KITTITAS COUNTY COMMUNITY DEVELOPMENT SERVICES

March 25, 2019

Subject: Ranch Road Performance Based Cluster Plat (LPF-19-00002) Final Plat. – Staff Review and Request for Additional Information

RANCH ROAD PERFORMANCE BASED CLUSTER PLAT

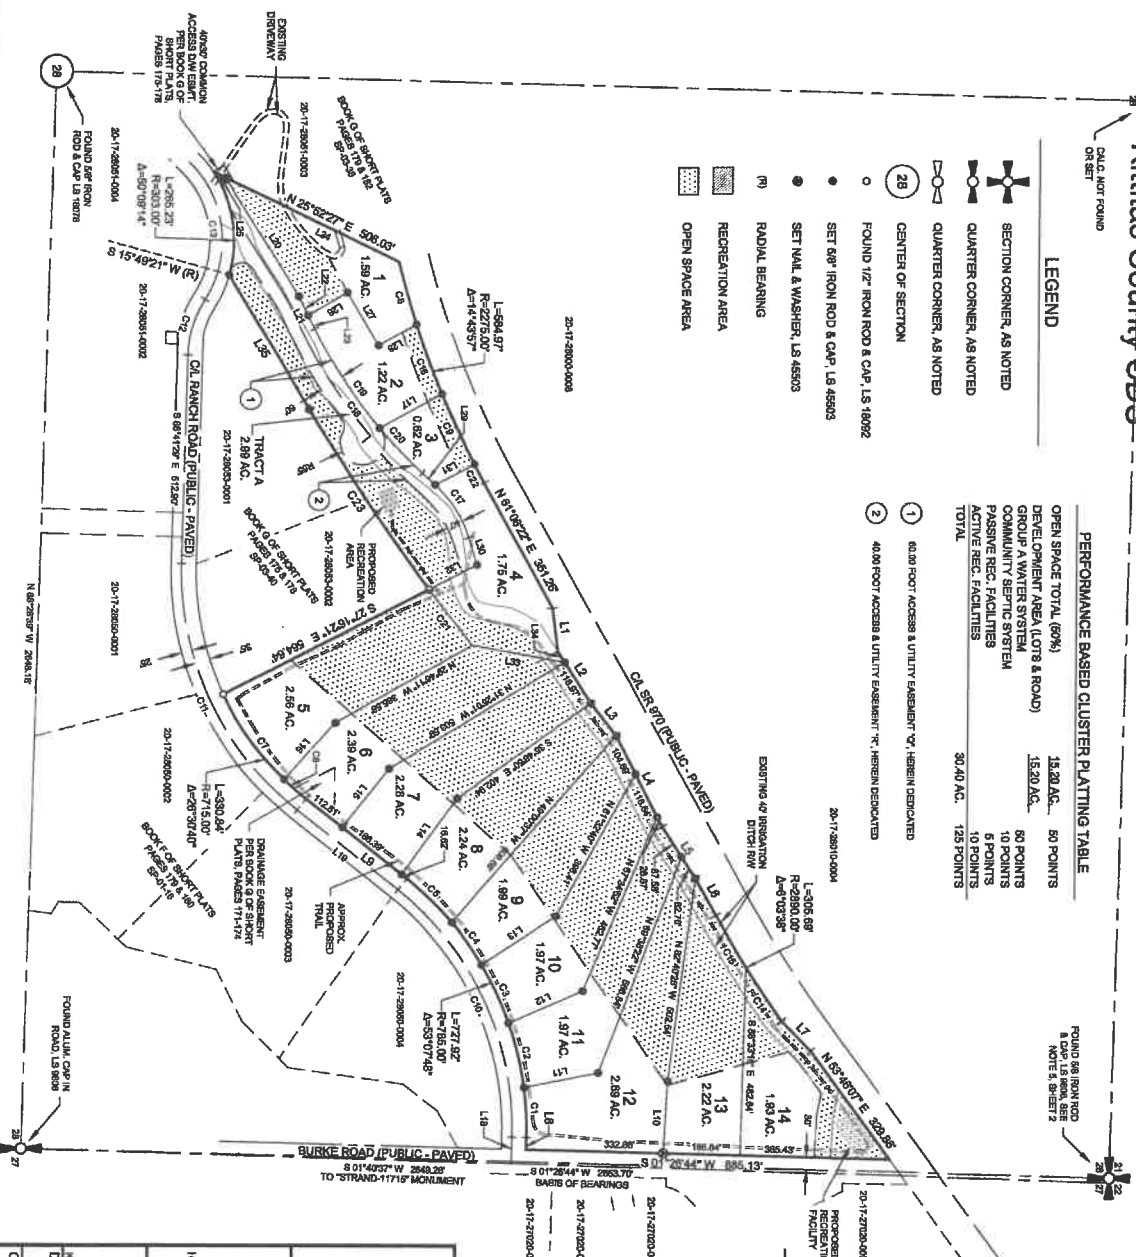
- 1) The dimensions for the North line of Lot 13, and the Northeast line of Lot 8 are obscured by crossing linework.
- 2) The division line between lots 13 and 14 should be monumented in the field.

- 3) The ownership of the public right of way should be clarified as being county or state.
 - a. EX: “Burke Rd- County R/W –Paved”
- 4) The open space limits are not retraceable/locatable.

- 5) The existing driveway serving lot 1 should include reference to the 20 foot access easement recorded under AF 2019031300003.
- 6) The access easement serving lots 2, 3, and 4 should be shown as dedicated right of way OR clear language included on the face of the plat that the entirety of Tract A shall fall under the ownership of a homeowners association, so as to protect the county from undesired ownership through absentee land tax.
